Mellor Parish Council

3rd November 2012

3/2012/0876 Land off Victoria Terrace, Mellor Brook.

Proposed development of 3no. houses.

site cross section 1:200

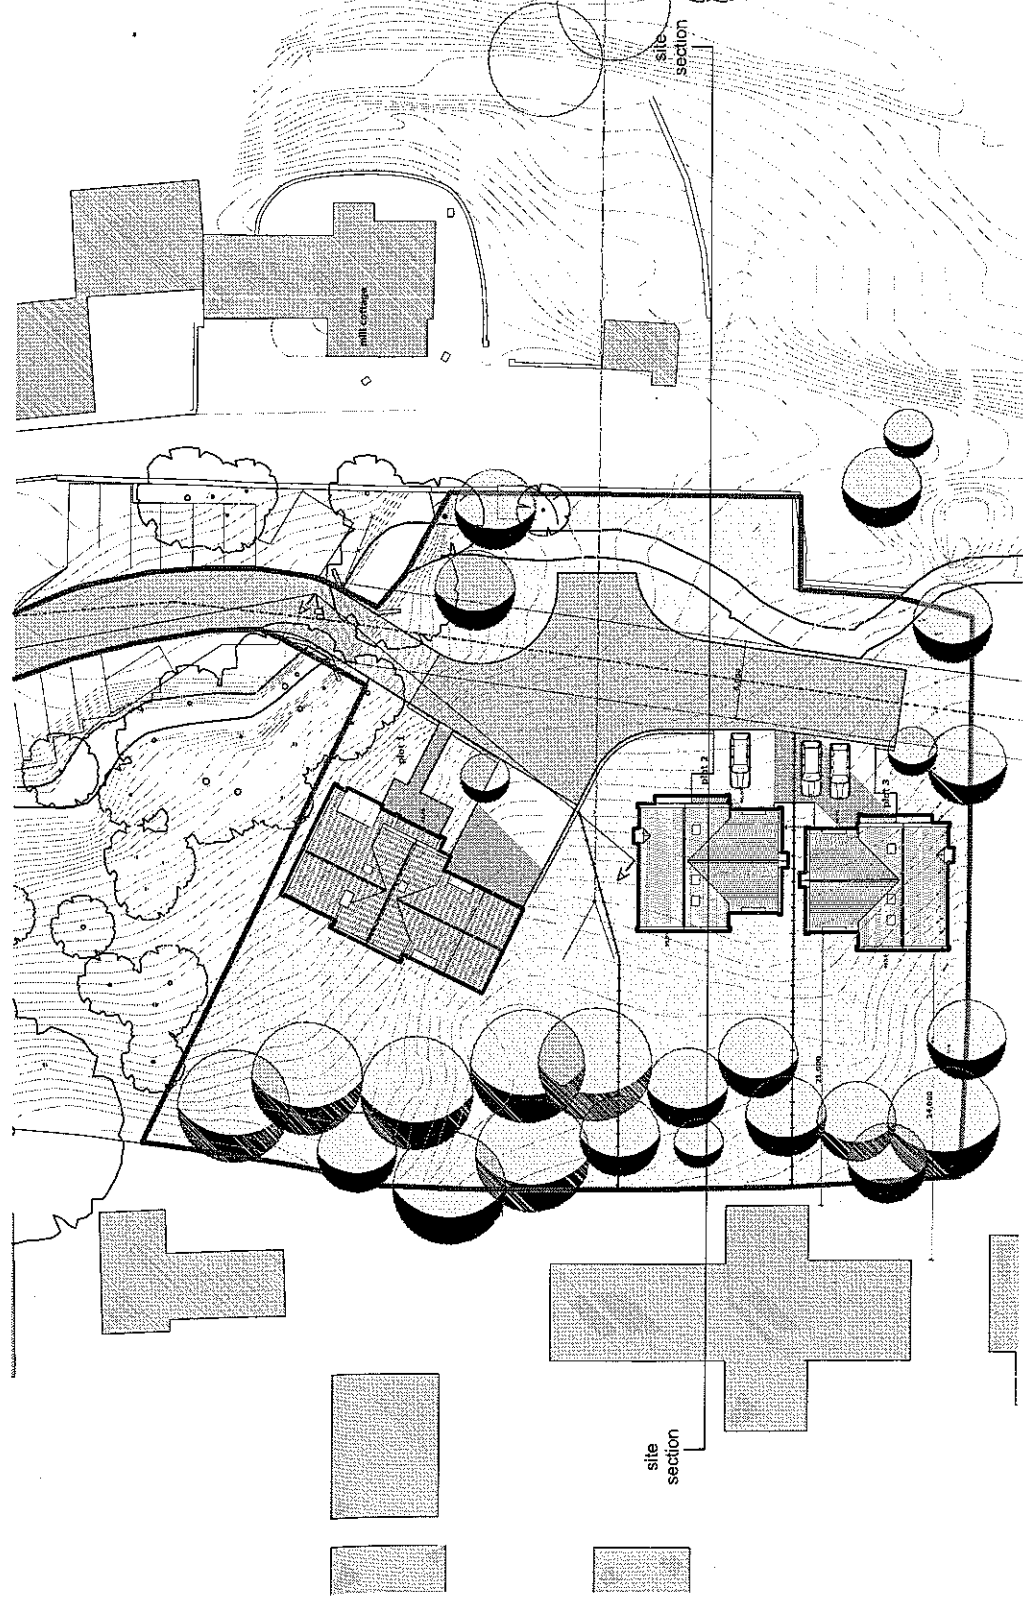
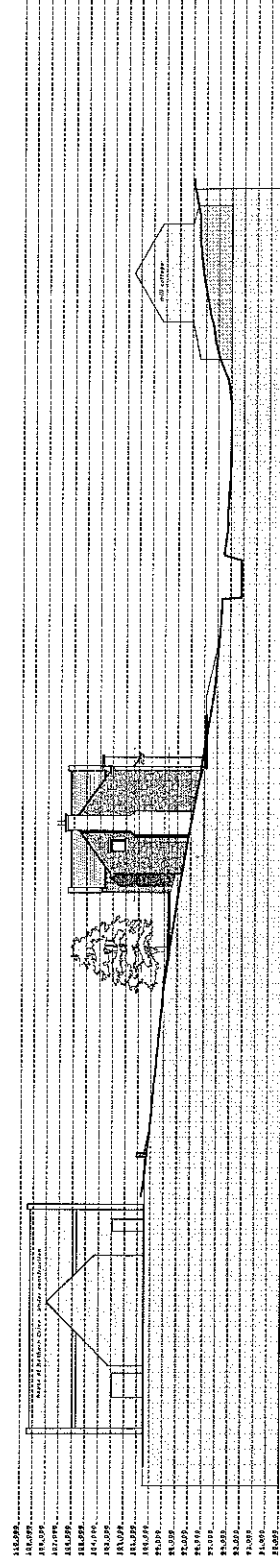
- 1 The building height at three storeys overlooks/ overshadows existing smaller properties
- 2 The large properties are for five bedrooms with two on three storeys It is likely that therefore even more vehicles will be based in the properties
- 3 The findings of the ecological survey need to be confirmed as satisfactory
- 4 Mellor Brow is already a narrow lane and this will exacerbate the situation at the very point where constriction becomes acute
- 5 Mellor Brow/Mellor Lane has become a thoroughfare for vehicles using the BAE industrial complex, roads which were never designed for the current usage Mellor Brow does not even enjoy the benefit of an overall footpath
- 6 It is hard to understand how Policy G1 of the Districtwide Local Plan is conformed to, despite assertions to the contrary in the proposal.
